RE: **Lot 35 Block 6 Unit 2 SAD 227**  
**7904 Kibo NW**  
**Volcano Cliffs Subdivision**  
**Grading and Drainage Plan**  
**Engineers Stamp Date 1/10/19 (E10D056)**

Based upon the information provided in your submittal received 1/10/19, this plan cannot be approved for Grading Permit until the following comments are addressed.

ENGINEER'S SEAL	Title: LOT 35, BLOCK 6, VOLCANO CLIFFS NO. 2	DRAWN BY
	CONCEPTUAL GRADING AND DRAINAGE PLAN	DATE
	RHD Engineering, LLC 4305 Purple Sage Ave. NW ALBUQUERQUE, NM 87120 (505) 288-1621	SHEET # X of X
	Richard Dourte P.E. #10854	JOB #

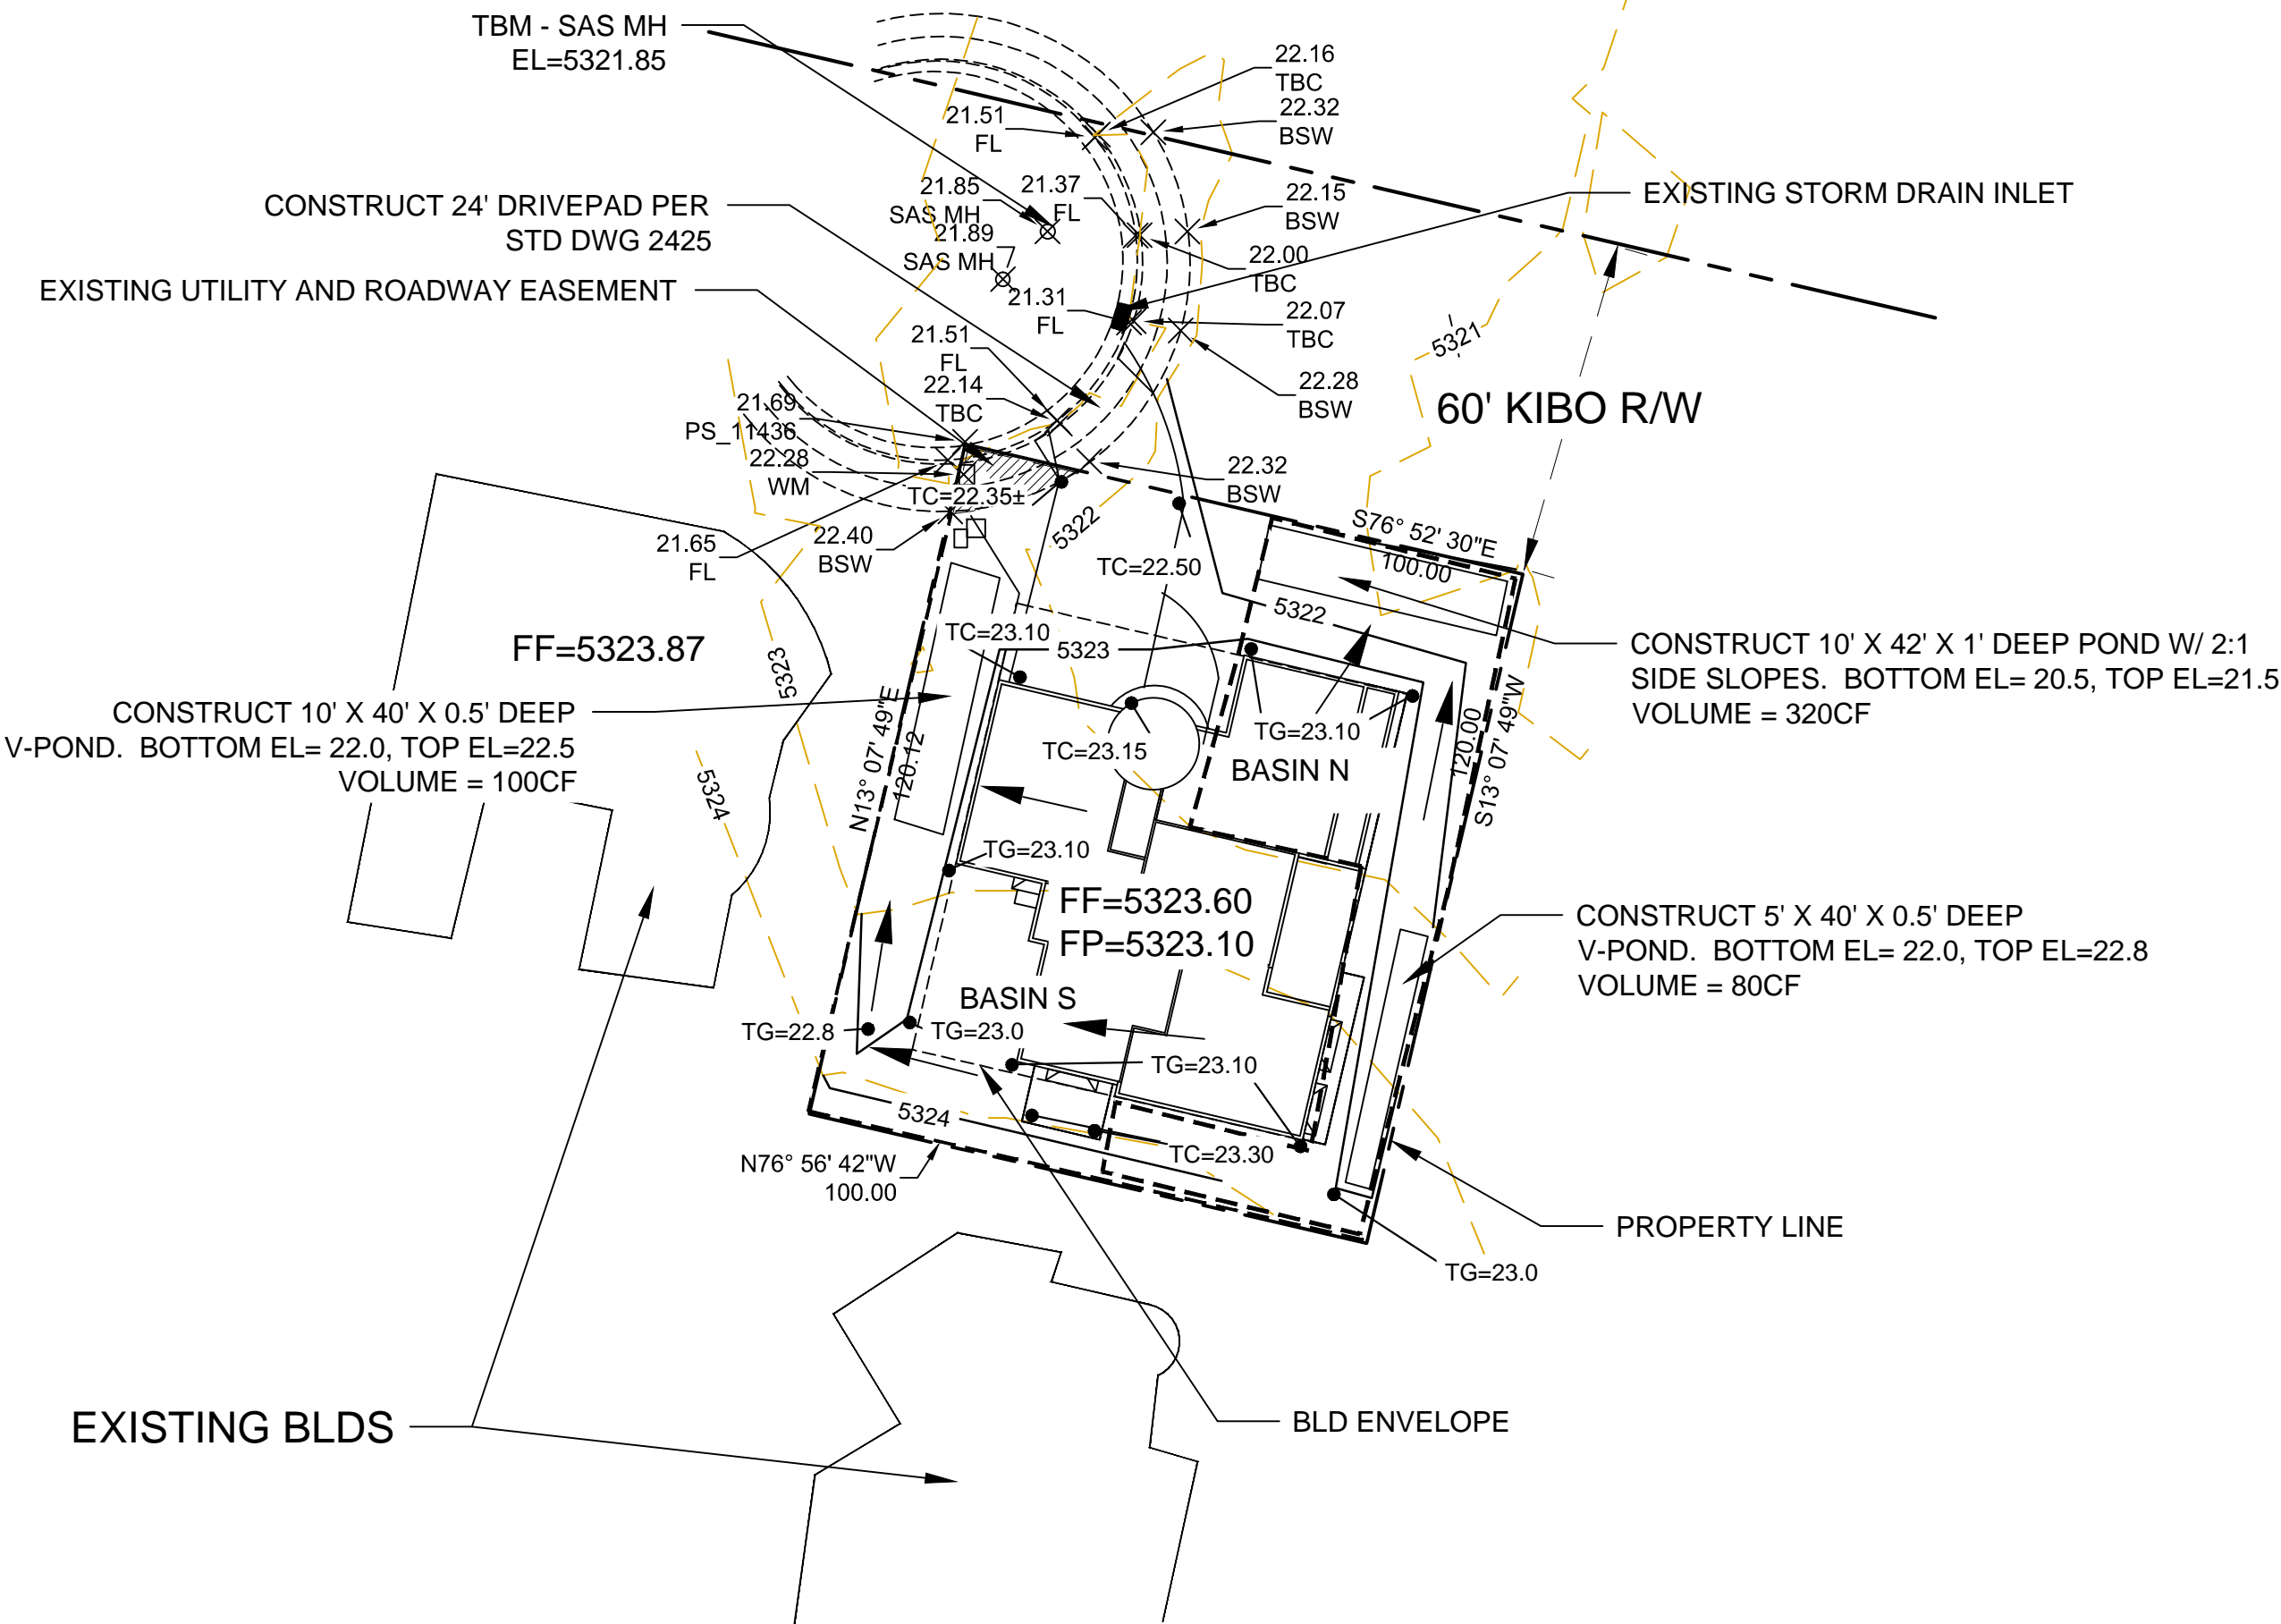
- Provide a scale and the north arrow.
- Provide the property line for the entire site.
- The driveway appears to be entering the site through another property, clarify.
- Provide a benchmark.
